Camden Council

RE: State Significant Development Application SSD 7424 – Notice of Response to Submissions

PROPERTY: 52 Anderson Road, Smeaton Grange
Lot 319, DP 1117230

drawing title  
GROUND FLOOR PLAN

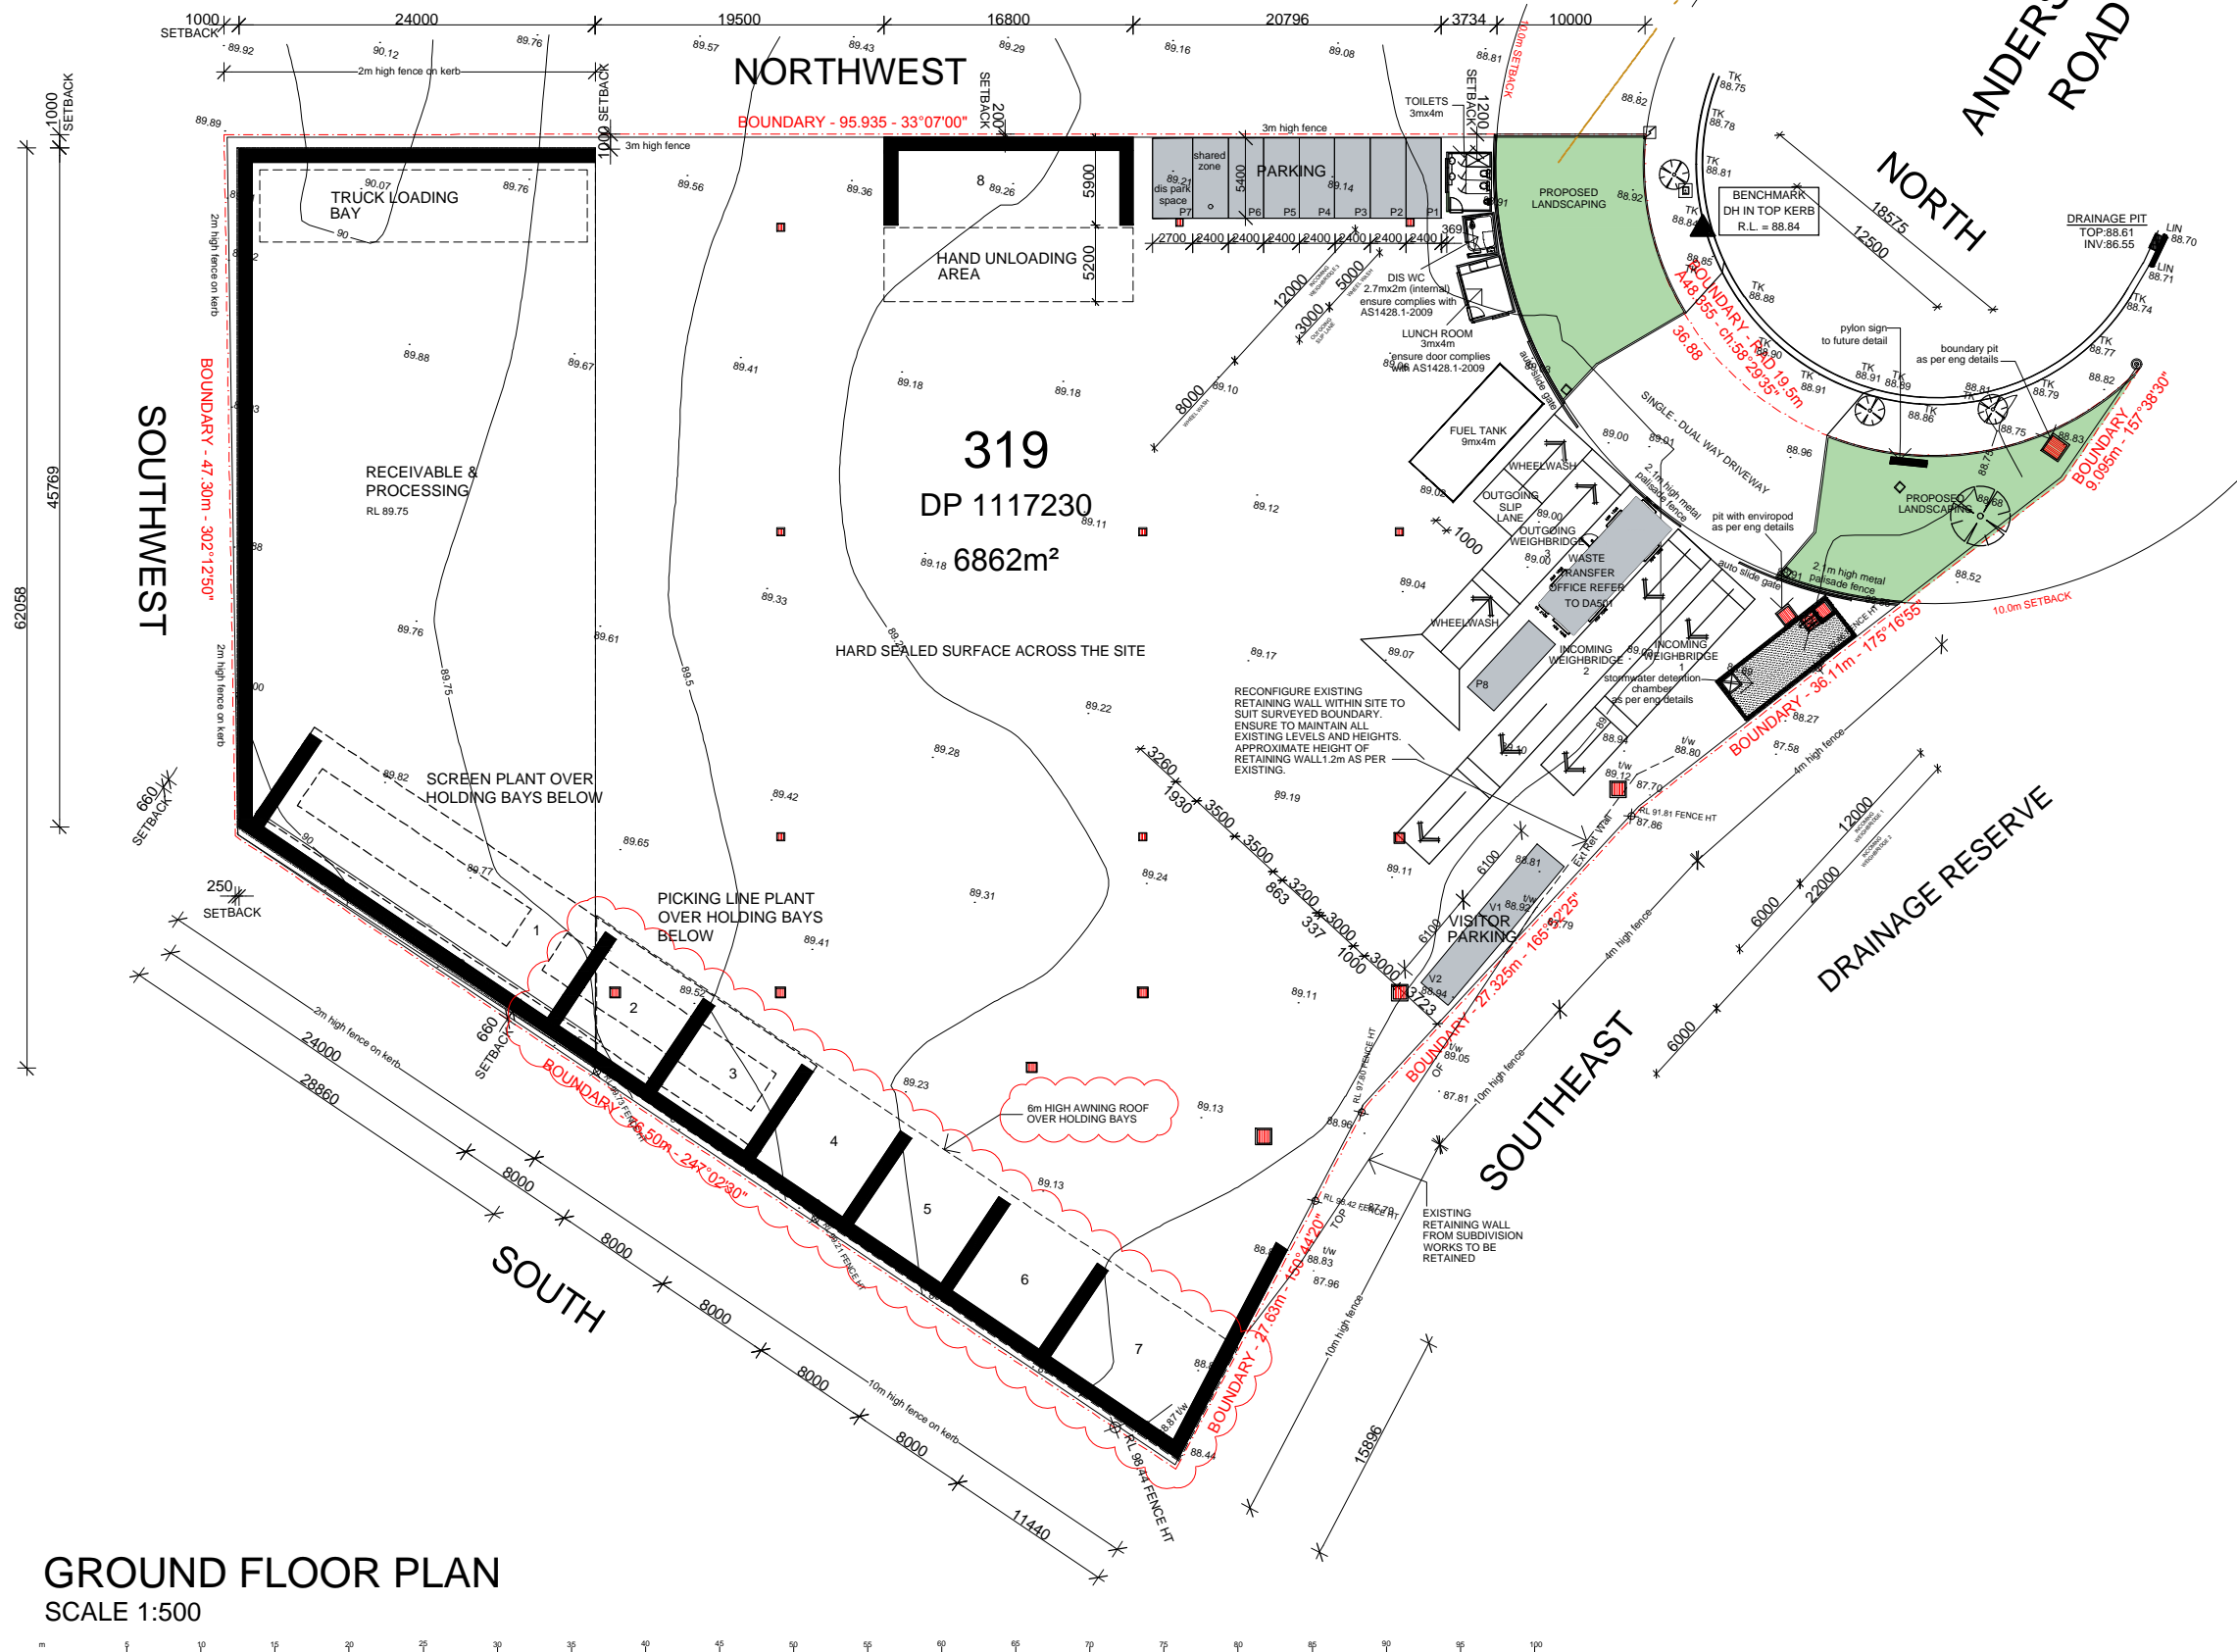
The RTS specifies there was an error in the initial description of the total number of staff. The assessment should have considered parking requirements for 8 employees and 2 visitors on site at any one time rather than 15 employees and 2 visitors. The site plan also incorrectly showed 7 parking spaces.

Council staff are satisfied that parking has been addressed with the provision of 10 spaces for 8 staff and 2 visitors. This is on the basis that the number of staff and visitors on site at any given time will be conditioned to not exceed 8 employees and 2 visitors. Council does not permit parking to be undertaken within the cul-de-sac or within the front setback/landscaped area.

drawing title  
ELEVATIONS 1

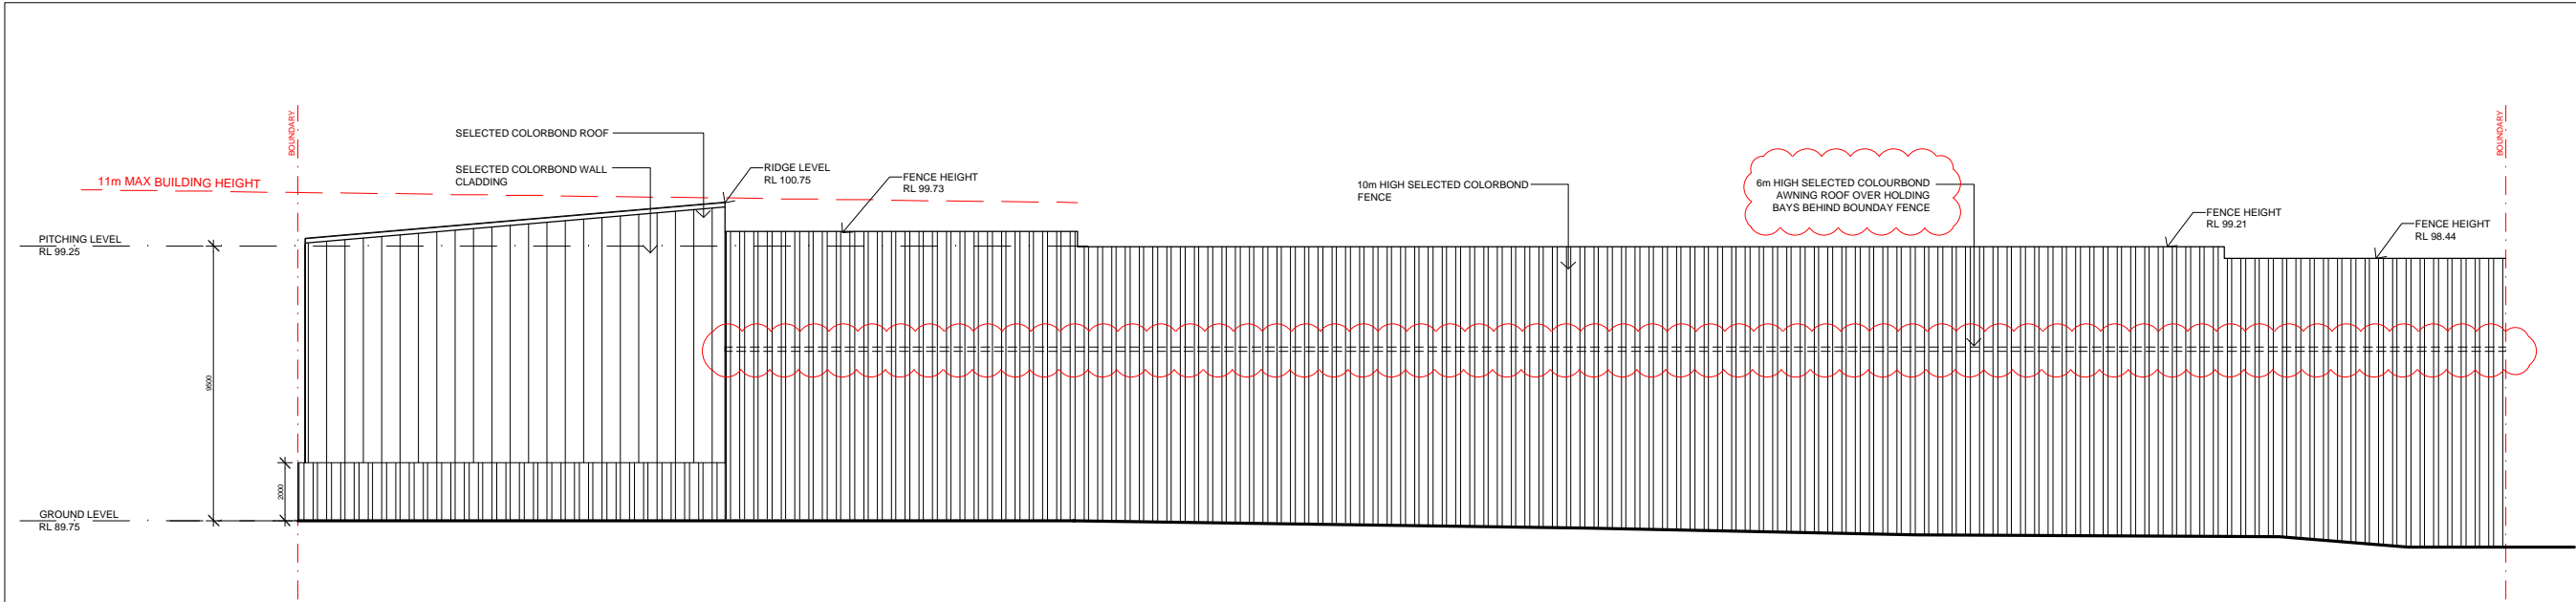
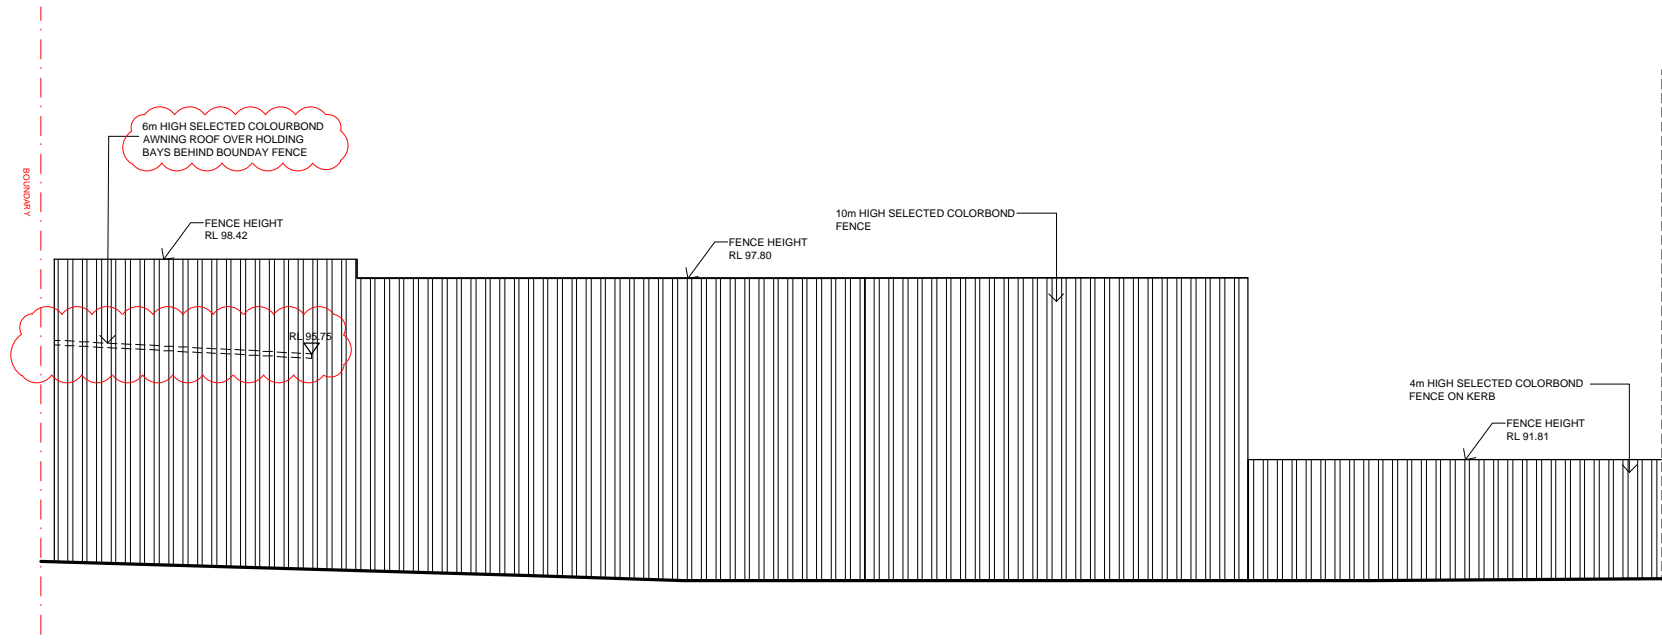
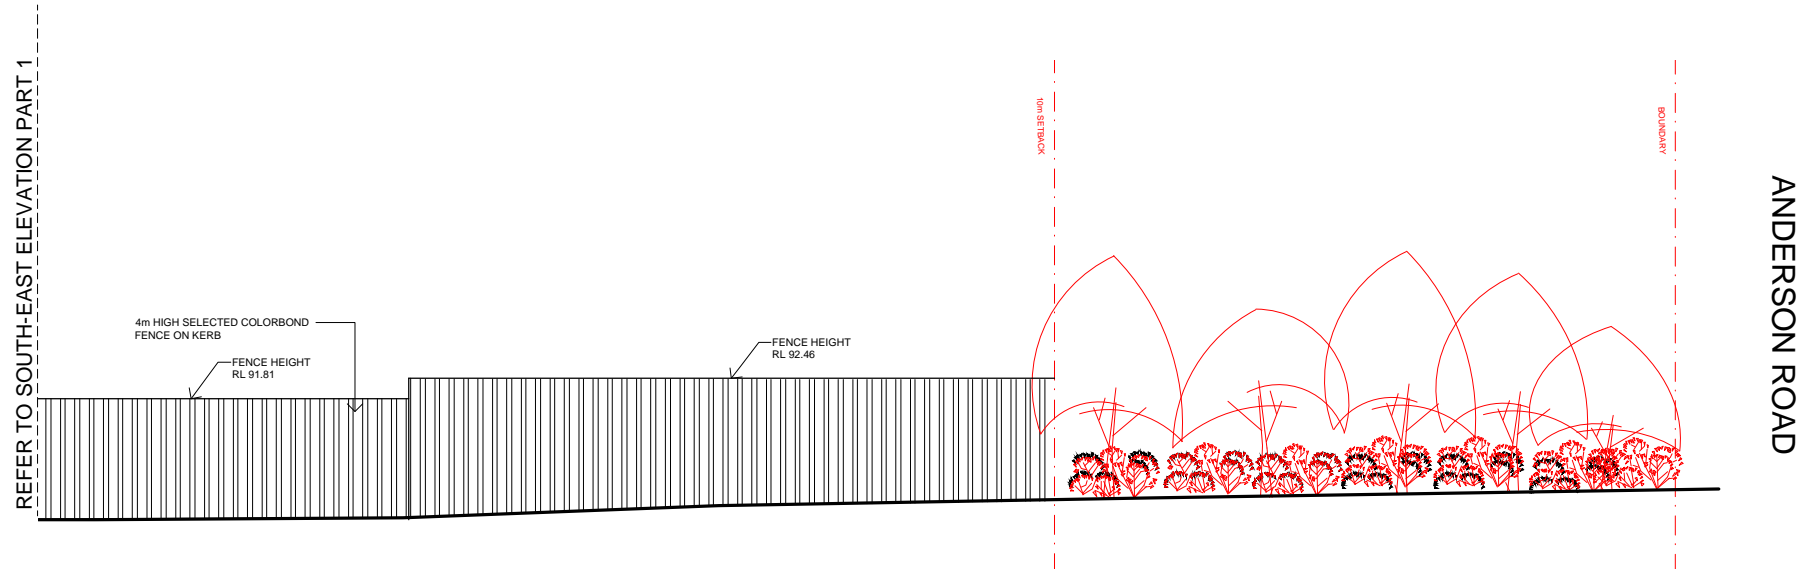
Architectural Plans - The revised site plan demonstrates the confirmed levels. The maximum height of the building shall not exceed 11m from natural ground level. A condition should be imposed to ensure compliance with the maximum building height.
